ABNORMALS COMMENTARY

**PROPOSED RESIDENTIAL DEVELOPMENT
KERESFORTH ROAD, DODWORTH,
BARNSELY**

CP VIABILITY

**REV A
JANUARY 2026**

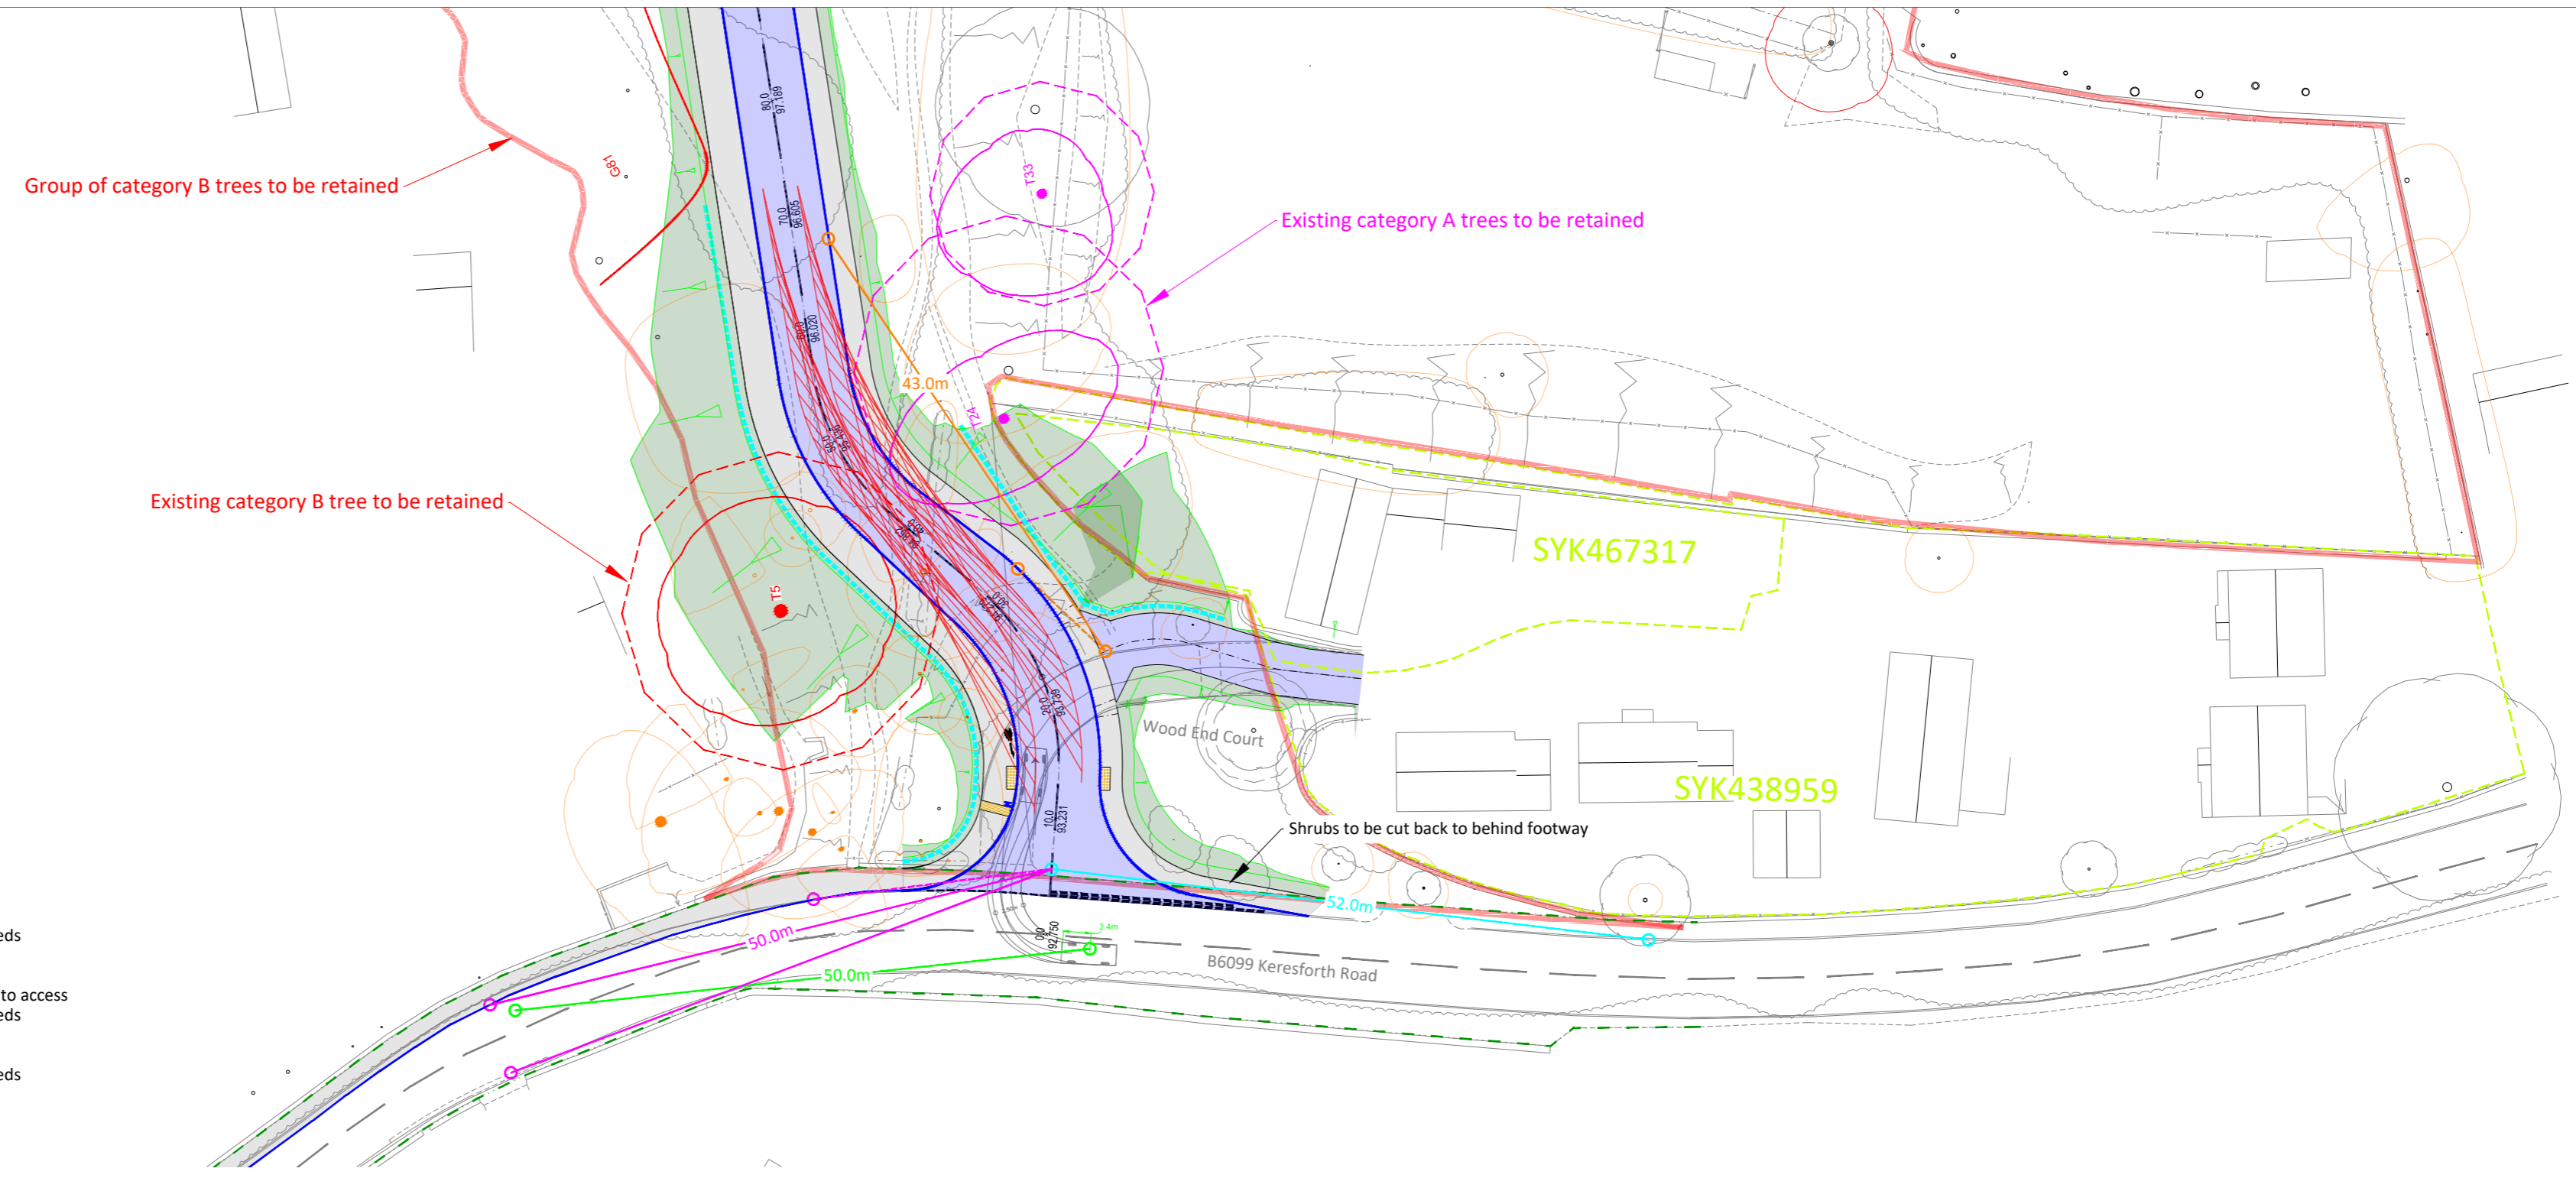
- 4.22 Highways – Access Works; £1,201,821
We have reviewed new information outlining the extra requirements on this site over and above what would be considered typical. We note the composition of lump sums, and in our experience, these appear to be costed within reasonable limits. We are prepared to accept the £1,201,821 as a reasonable abnormal cost.

FOUNDATION SCHEDULE

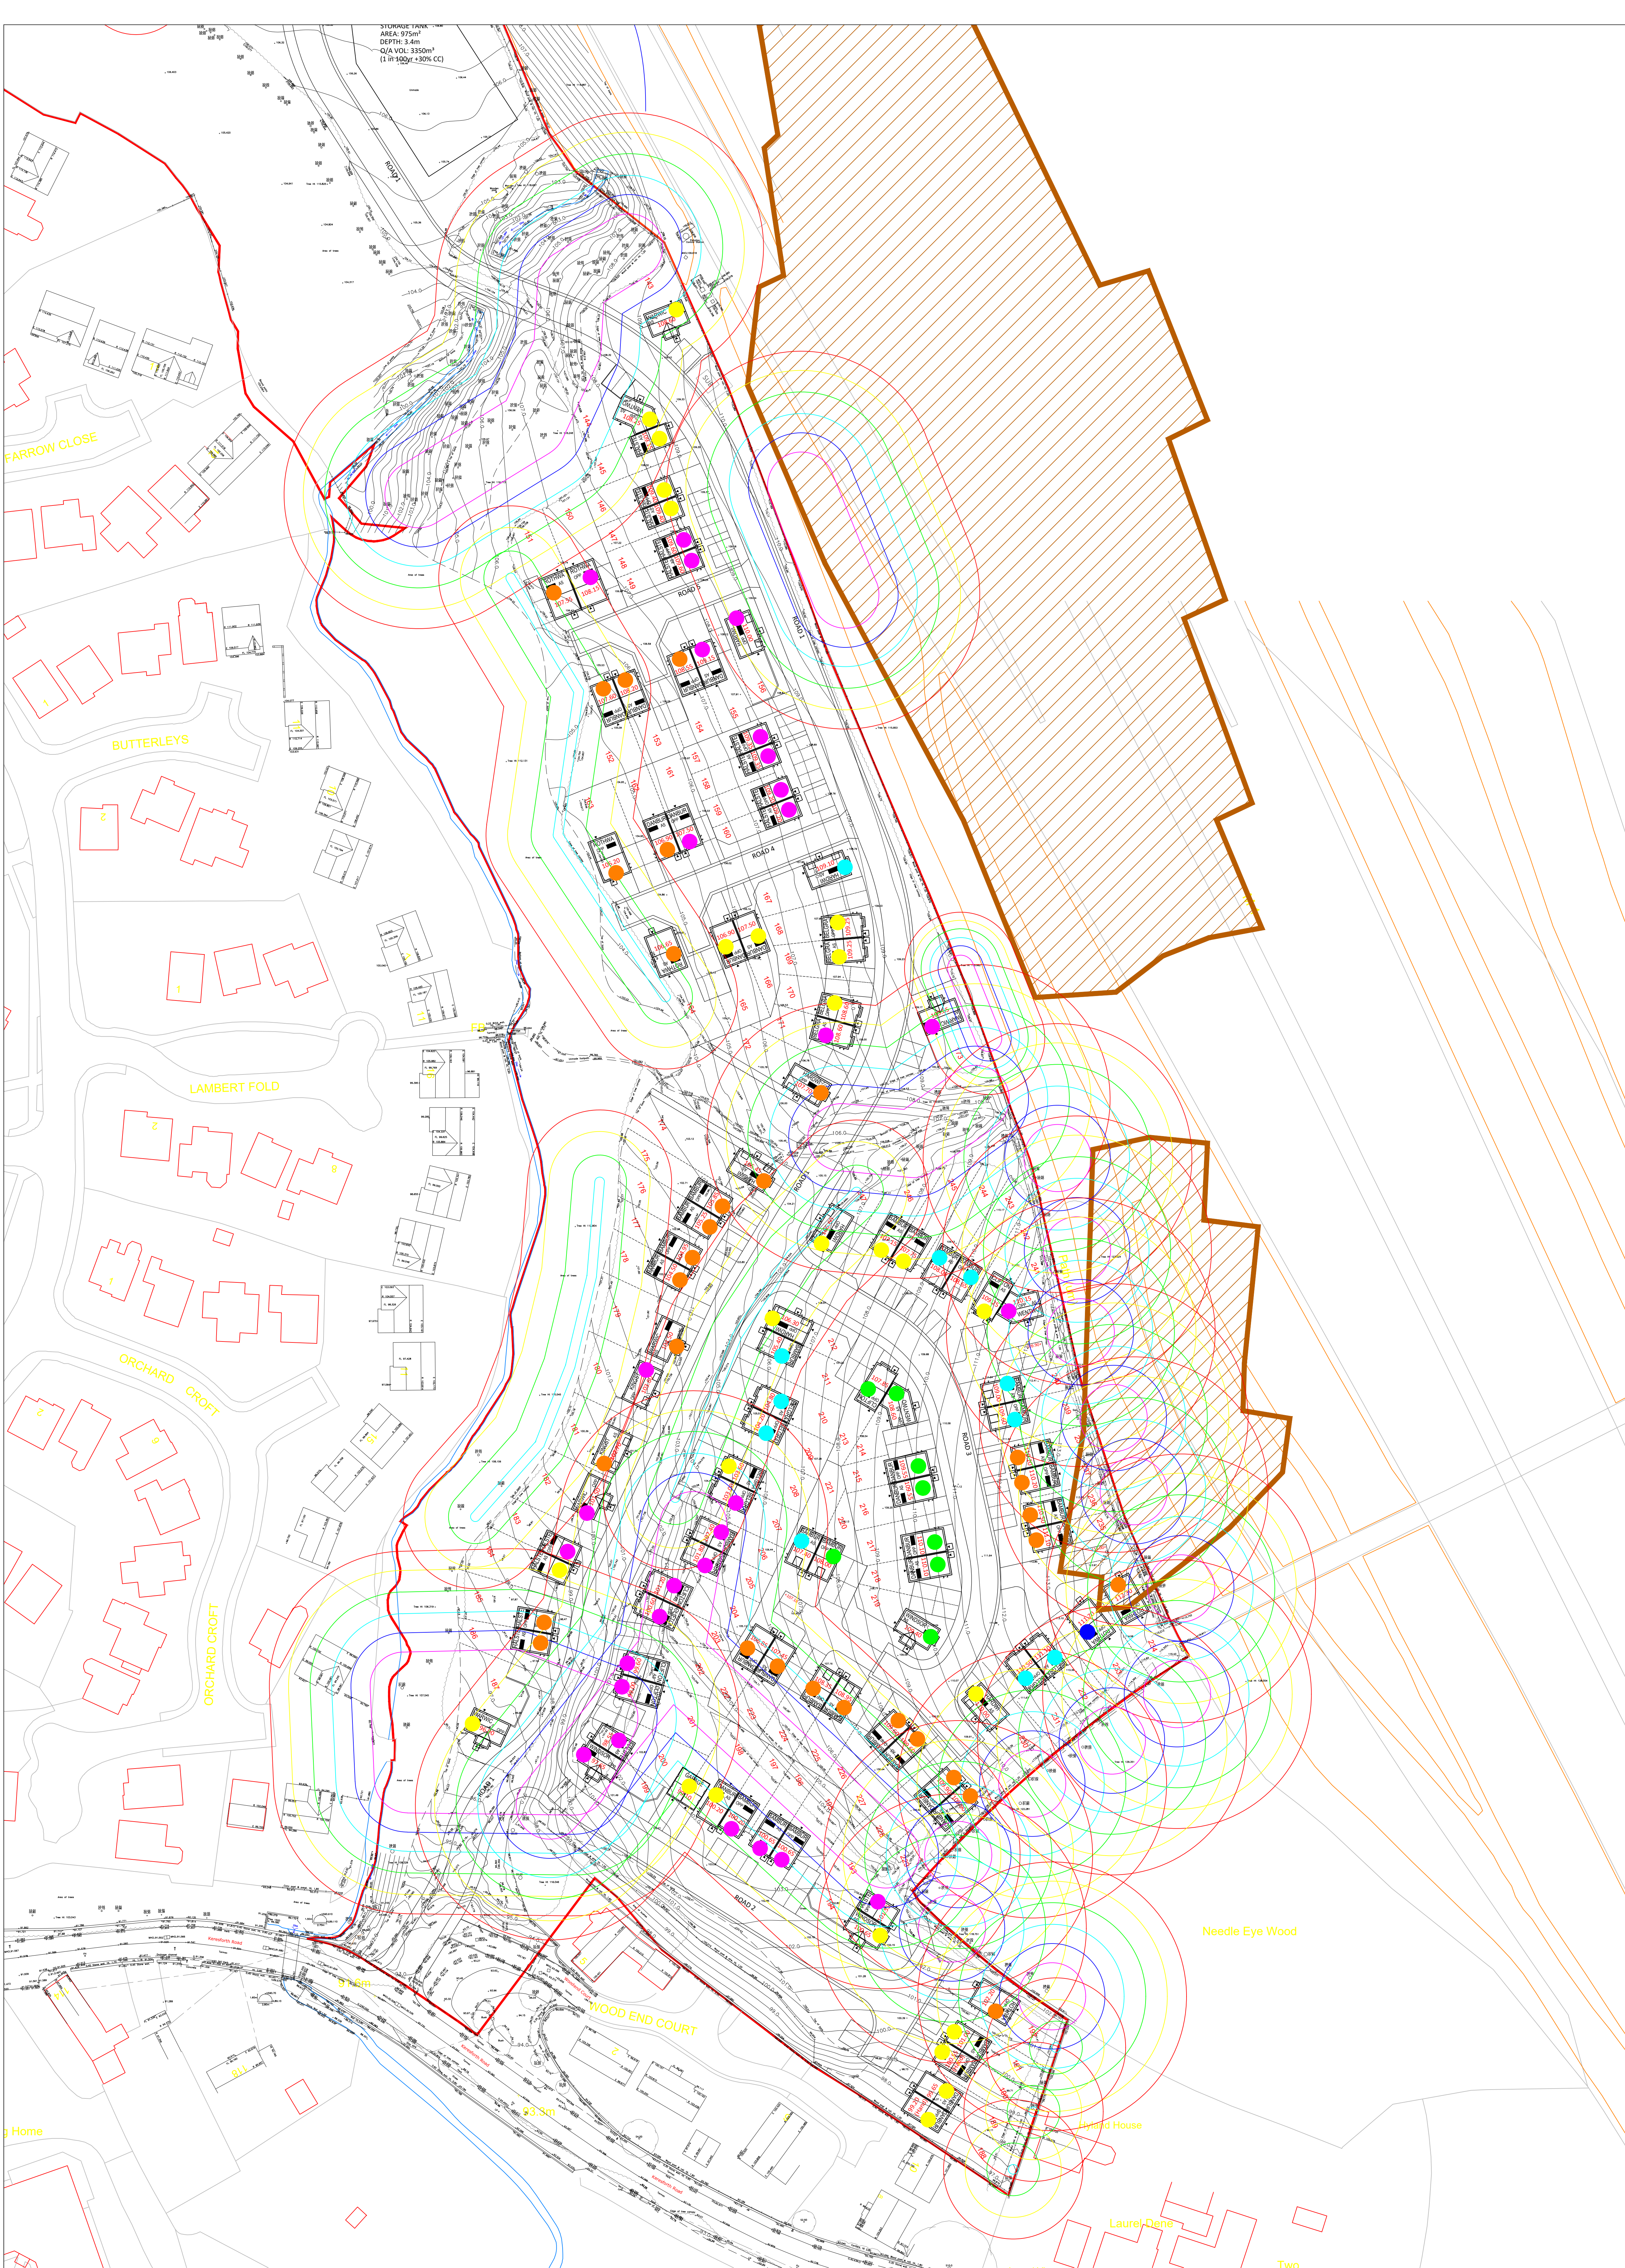
- 4.01 Substructure – E/O Trench; £158,496
We have reviewed new information supporting the need for deeper foundations and note conflicting drawn information that we are unable to reconcile. We would require correct drawings from the Applicant for us to review this as an abnormal.

-
- 4.02 Substructure – Driven Piles; £592,669
As per our comment for Item 4.1, we have reviewed new information supporting the need for deeper foundations and note conflicting site layout plans and we are unable to reconcile the full cost data. We would require correct drawings for us to review this as an additional cost.

- 4.03 Substructure – Reinforcement; £67,200
As per our comments for Items 4.1 & 4.2.
- 4.04 Superstructure – Future Homes Standard; £762,300
Compliance with the Future Homes Standard will be mandatory beyond December 2026 with a 12-month transition period until December 2027. It is unclear whether any of the plots will have substantially commenced after December 2027 to validate this as an abnormal cost item.

HV & LV Diversions
Keresforth Road
Dodworth

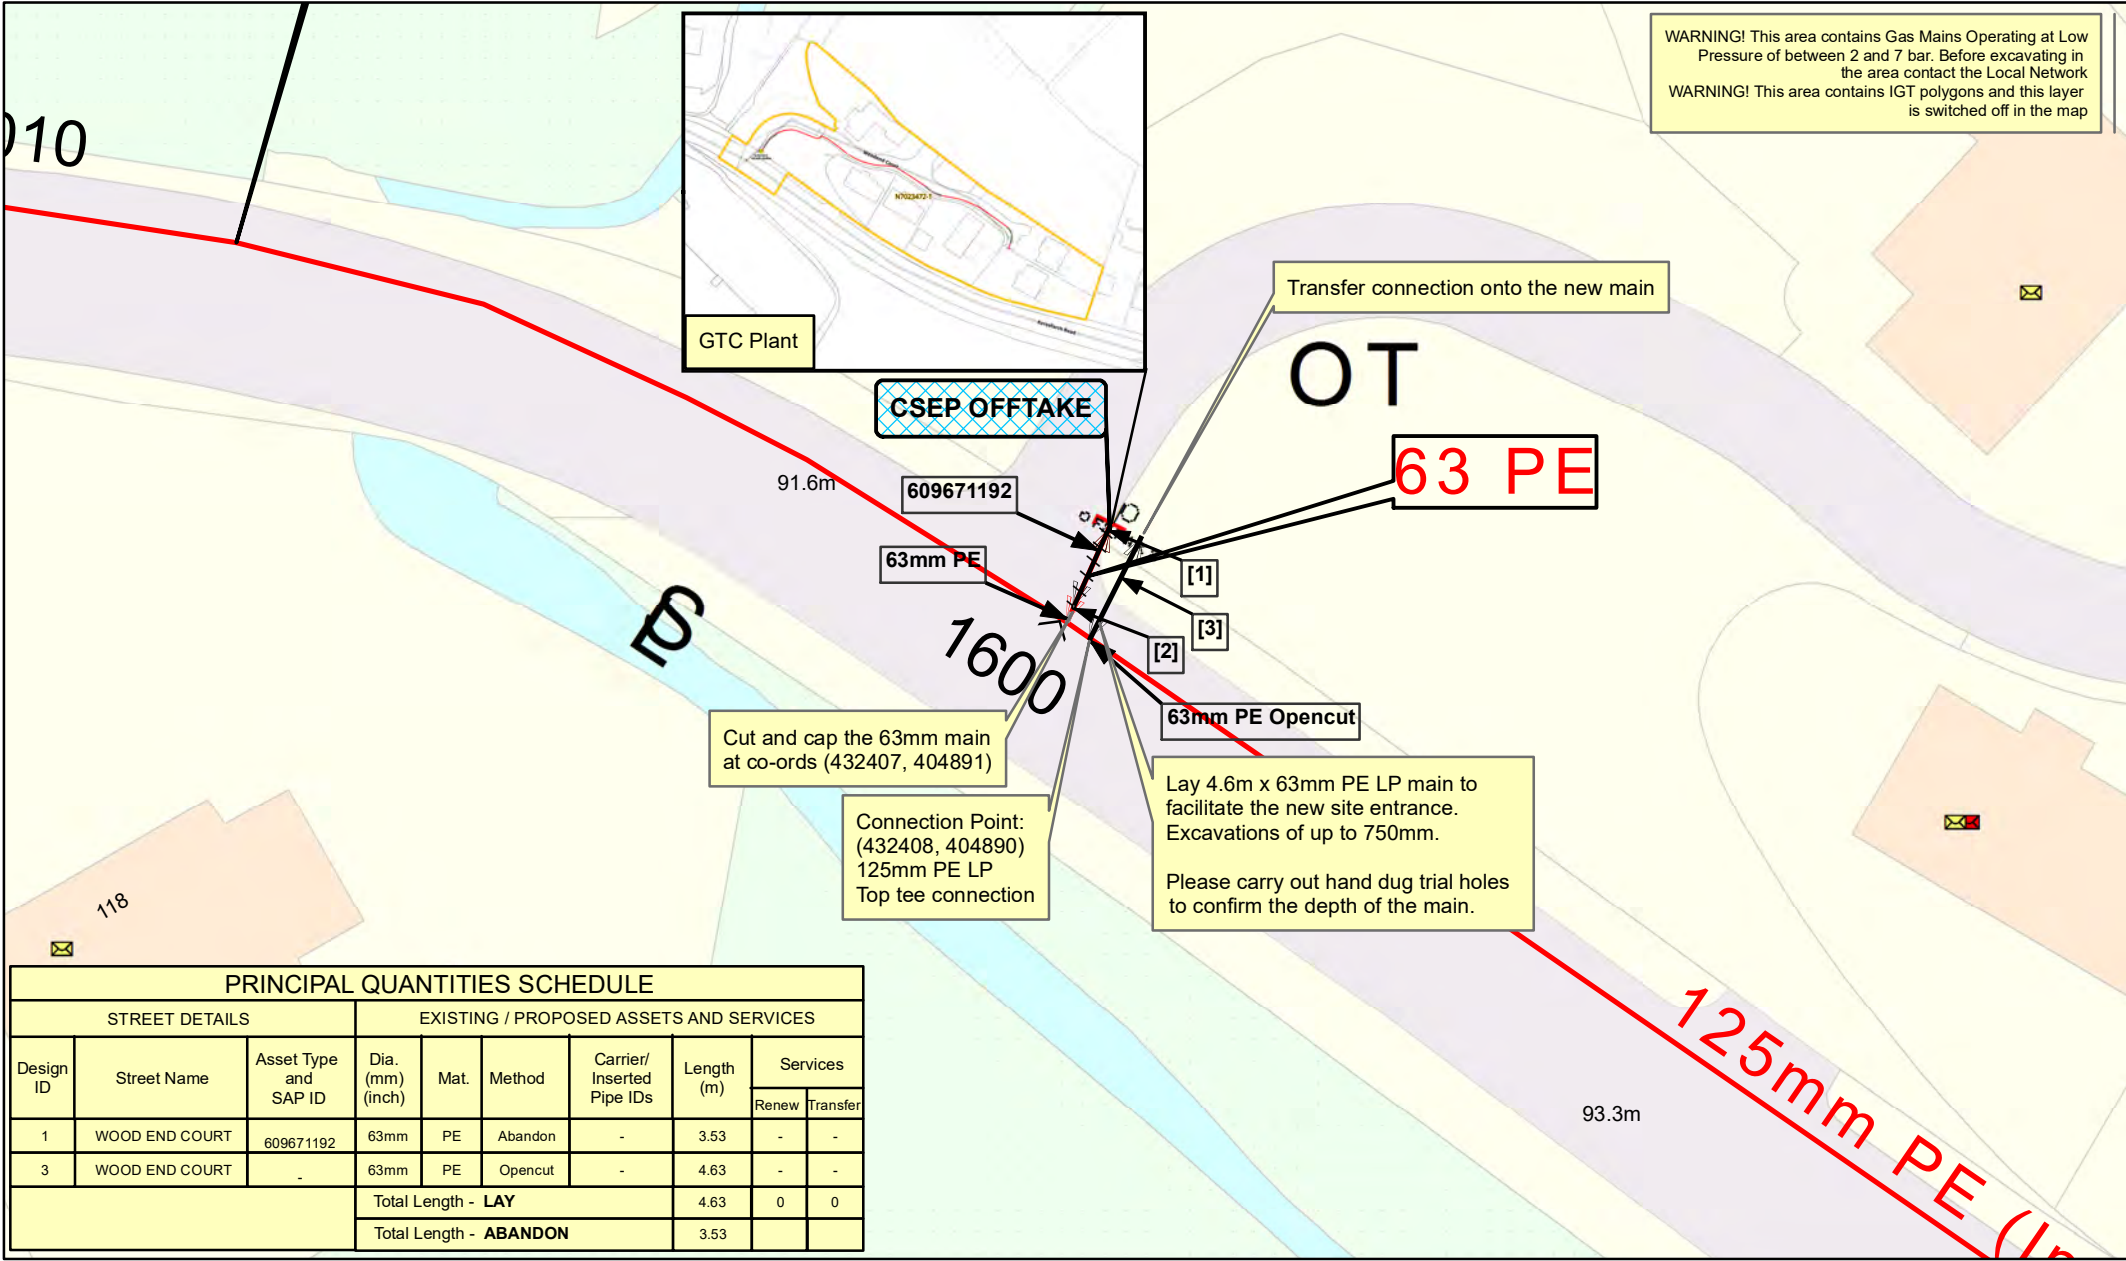
- 4.19 Site Preparation – Stat Diversions; £77,320
Whilst we note the site is a greenfield site without any known statutory services, we have been provided with evidence to show utility services across the proposed southern entrance. And which would need to be diverted to accommodate the construction of a new site entrance. The lump sum costs for Openreach, NPG, Gas and street lighting appear reasonable.
